**KIRKLEES METROPOLITAN COUNCIL
INVESTMENT & REGENERATION SERVICE**

Reference No: 2020/62/90167/W

Site Address: 60, High Street, Scapegoat Hill, Huddersfield, HD7 4NJ

Description: Erection of single storey rear extension and first floor extension with balcony and alterations to convert garage to extend living accommodation

GA Elevations as Proposed

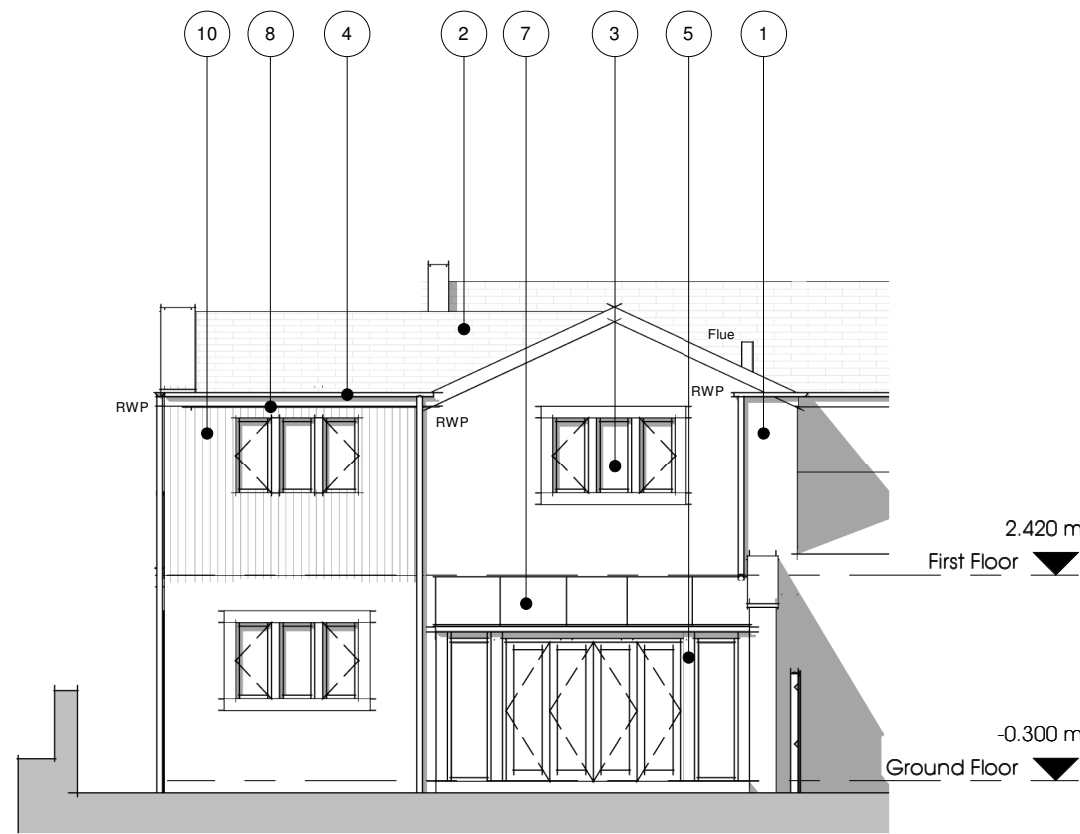
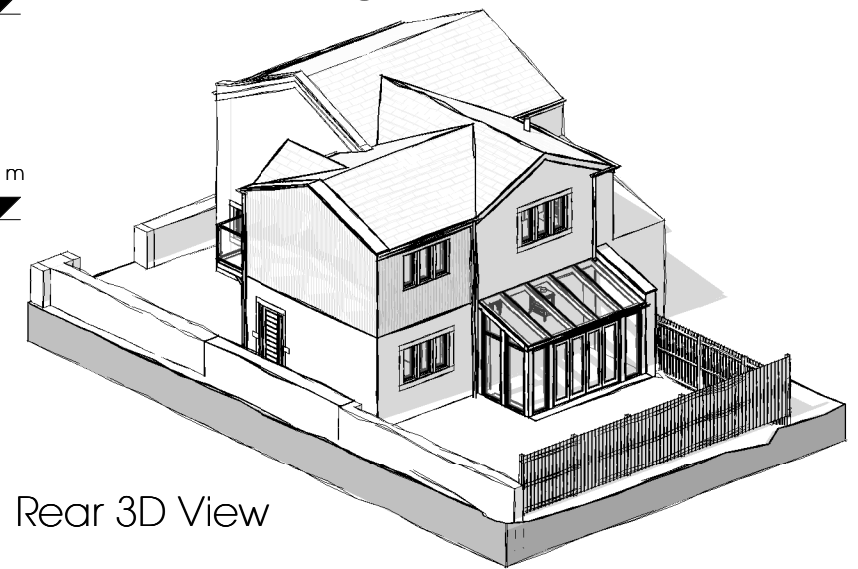
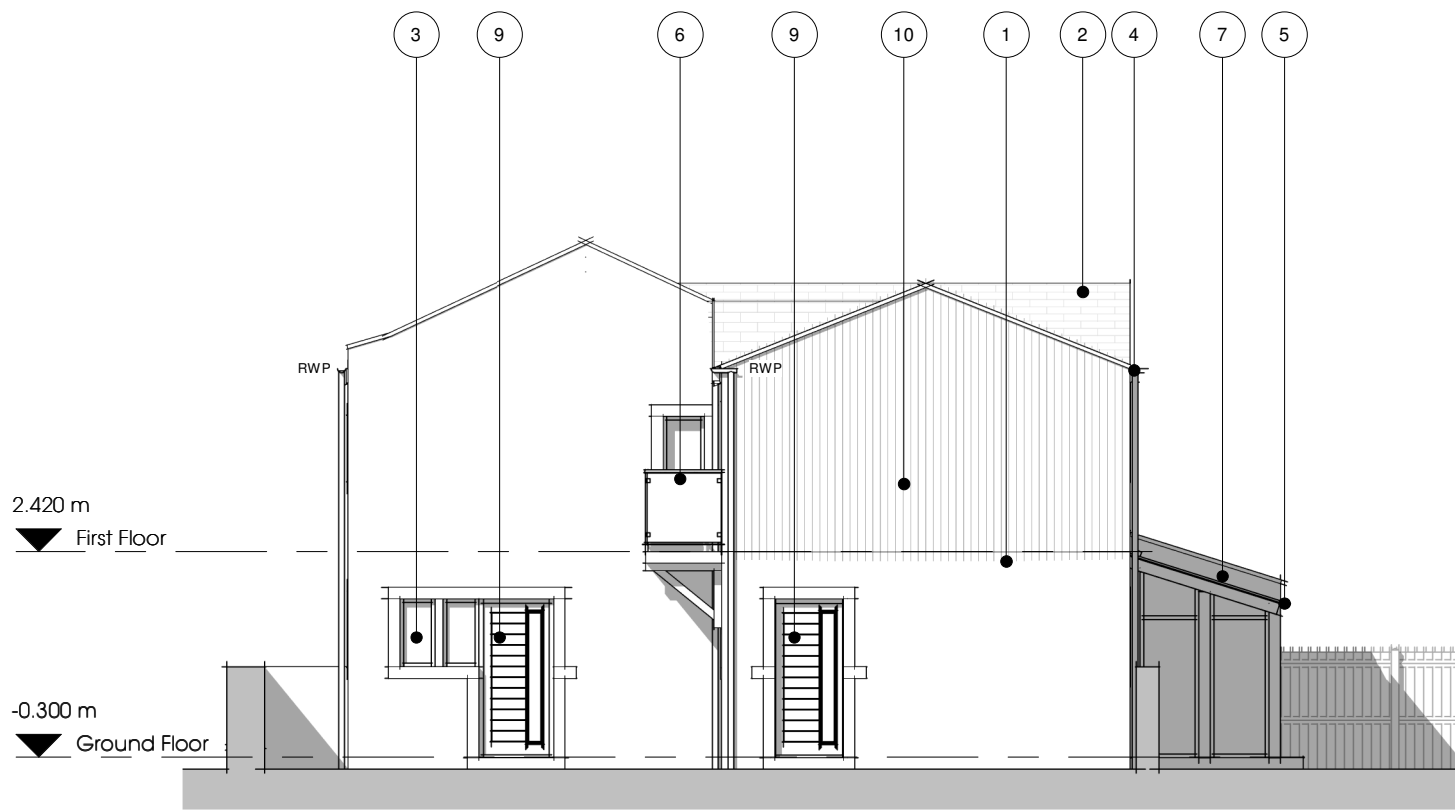
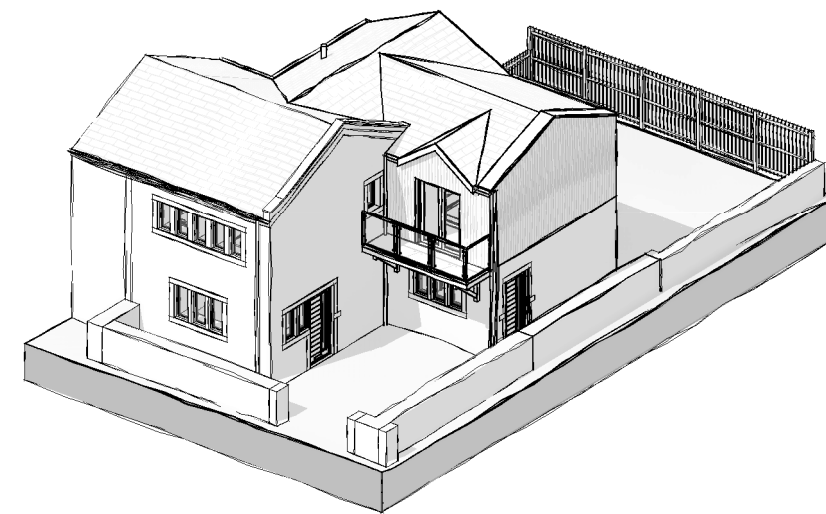
The proposed development will significantly extend the application property, detracting from the form and dominance of the original building. LP24 (c) states that extensions should be subservient to the original building, in this instance given the scale and mass of the proposed extensions, they would not appear subservient. This is both in terms of the mass created and the proposed design. The existing building is a modest end-terrace of vernacular style. It has a single storey outrigger, which may have been a common feature with other properties in the row. Whilst the erection of an extension above the outrigger, similar to one along the row, and the conservatory could well be undertaken whilst leaving the original dwelling the dominant element on site, the addition of a large two-storey side extension in conjunction with this would not. It would lead to a complicated roof form that detracts from the simple character of the terrace. The impact of the scale and mass of the extension is compounded by the detailing of the front elevation of the side extension. This includes the use of timber cladding, a decorative gable and projecting balcony: features that are incongruous in the otherwise simple terraced row. The balcony and timber cladding would also be clearly apparent when travelling west along High Street.

Considering the above, the proposed design of the new extensions would not be in keeping within the immediate area given its traditional appearance. The proposed design would not harmonise with the nearby existing dwellings along High Street which would have a detrimental impact to the visual amenity within the immediate area.

Regarding the use of timber cladding, it was noticed whilst the officer was on site that No. 22 Chapel Street, the neighbouring dwelling adjacent to the rear elevation is an 'eco house' with the use of cladding being a dominant material, however this dwelling is well hidden and can only be glimpsed along High Street. In addition, as cladding is not a common material along High Street,

with the use of stone being the primary material. The use of timber cladding will cause adverse harm to the traditional appearance of the surrounding dwellings along High Street.

Taking into account the above, it is considered that the proposal is an unacceptable form of development and would be detrimental to visual amenity, contrary to Policy LP24 (a and c) of the Kirklees Local Plan and advice within the National Planning Policy Framework.

The proposed extensions by reason of their mass, scale and design would not be subservient to the original dwelling or be in keeping with its scale, materials and detailing. The proposed development would not respect or enhance the character of the terraced row of which this dwelling forms part, or the wider street scene. It would thus be detrimental to the visual amenity of the area. To permit such a development would be contrary to Policy LP24 (a and c) of the Kirklees Local Plan and Chapter 12 of the National Planning Policy Framework.
